Reference No: 2019/62/91422/E

Site Address: 2, Nelson Street, Birstall, Batley, WF17 9EP

Description: Alterations and erection of rear dormer windows to convert existing building (A2) to 7 apartments (within a Conservation Area)

Officer Report

drawing title: PROPOSED PLANS SECTION ELEVATION,
project: CHANGE OF USE FROM A2-FINANCIAL TO C3- DWELLINGS
for MR A. BISAGGIO
scale 1:100 at A1
drawing no 2018-00457- P02 H

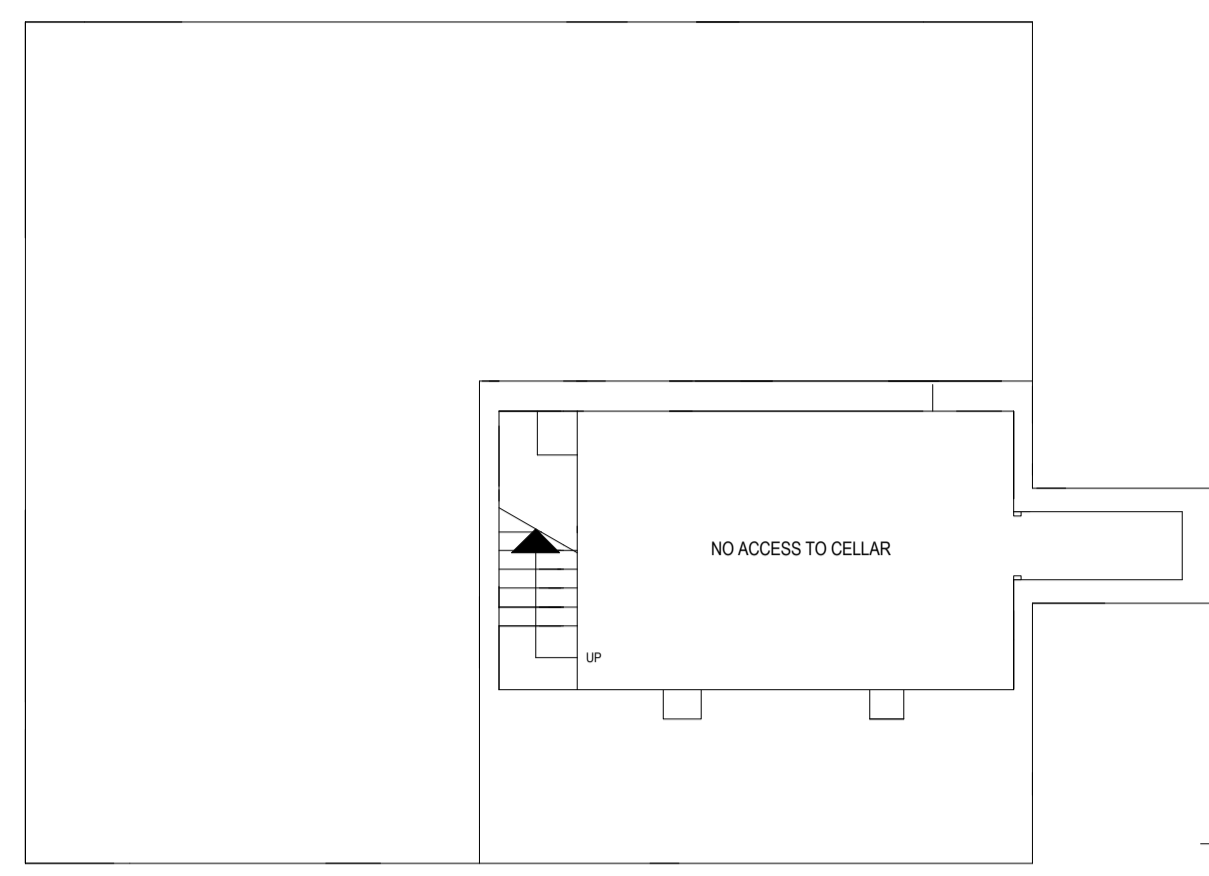
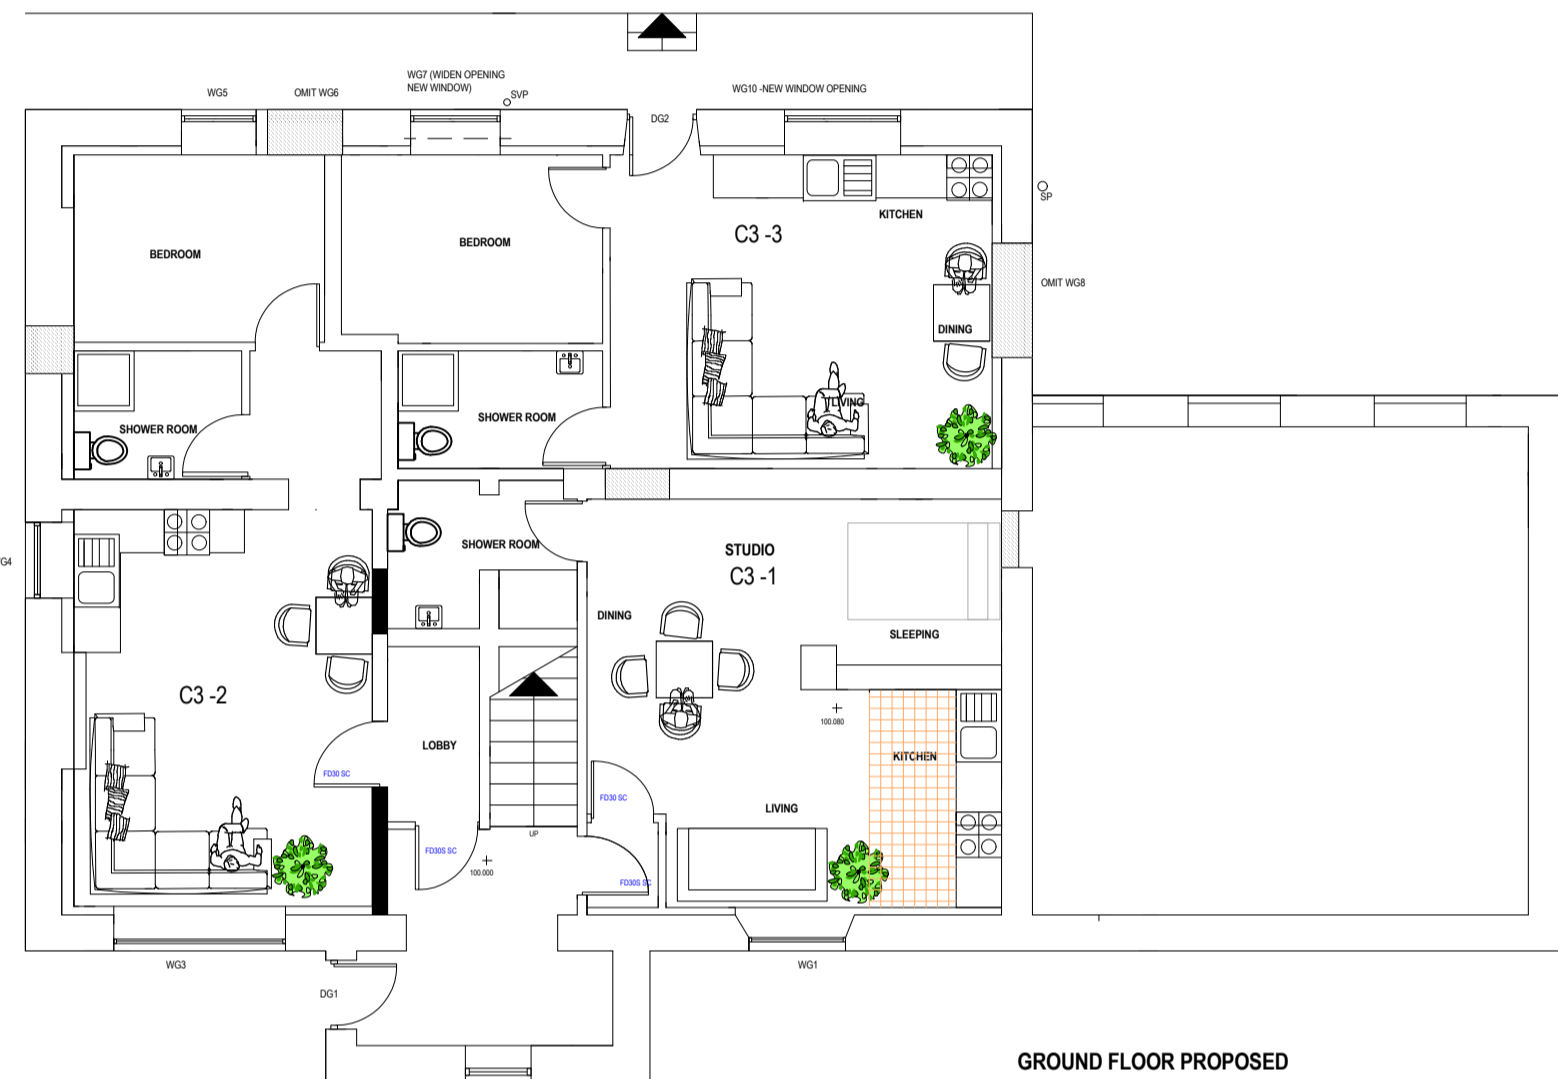
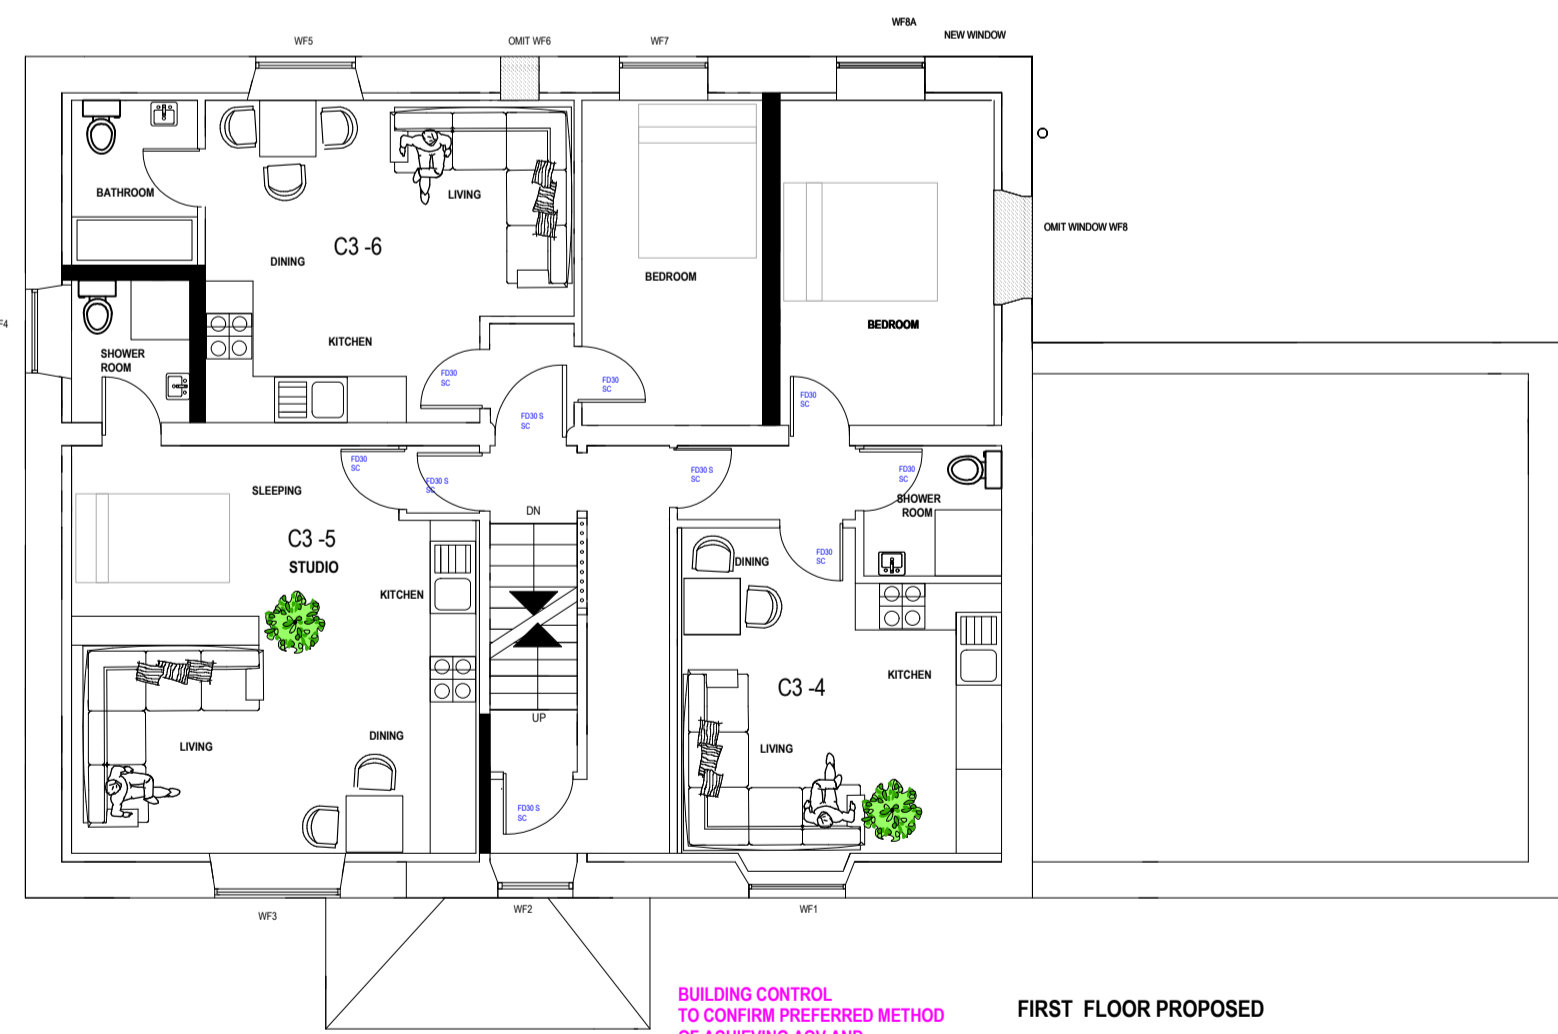
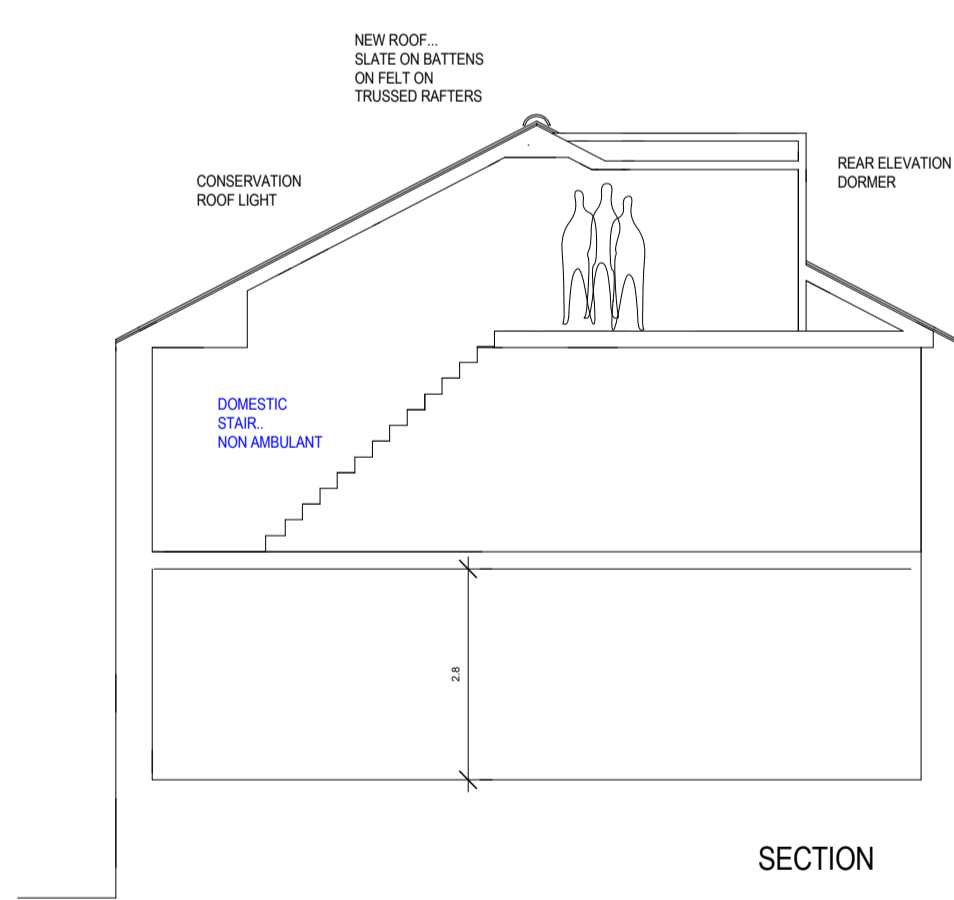
The submitted amended plans show that the front elevation of the building would remain largely unaltered; the two roof lights, as originally proposed have now been deleted at the request of the Conservation and Design officer.

One of the main alterations to the front elevation of the building would be the replacement of the roof covering. The applicant had originally proposed a dark Brazilian slate, however the existing roof covering is a natural, York stone slate and this would have altered the character of the building. The Conservation and Design officer has objected to this alteration.

The amended plans show the two dormers to the rear would now be of equal size and design and positioned so that they are equidistant from the sides of the building. This is considered appropriate and, due to the position at the rear of the building would not be visible from a public vantage point.

Within the east side elevation of no. 2 Nelson Street, the original proposals were for a kitchen/dining window at ground floor and a bedroom window at first floor level. These would have had a direct relationship with a bedroom window in the side elevation of no. 6 Nelson Street at a distance of around 8.5m.

Concerns were raised by the officer during the site visit and amended plans submitted showing these windows infilled and new windows inserted in the rear elevation of the building where they would cause no harm.

A site meeting was held with the applicant and it was suggested that the existing York stone slate should be retained and repaired where necessary, however the builder has stated that the slate is in a very poor state. The cost of replacing with natural stone slate in this location would be prohibitive and as such it was suggested that using a good quality artificial stone slate may be an alternative. The applicant has decided to use Grey's Artstone, natural weathered diminishing reproduction stone slate; this is considered a good match for the existing and other stone slate in the area.

4. The replacement roofing material shall be Grey's Artstone, natural weathered diminishing reproduction stone slate and shall be laid in diminishing courses.
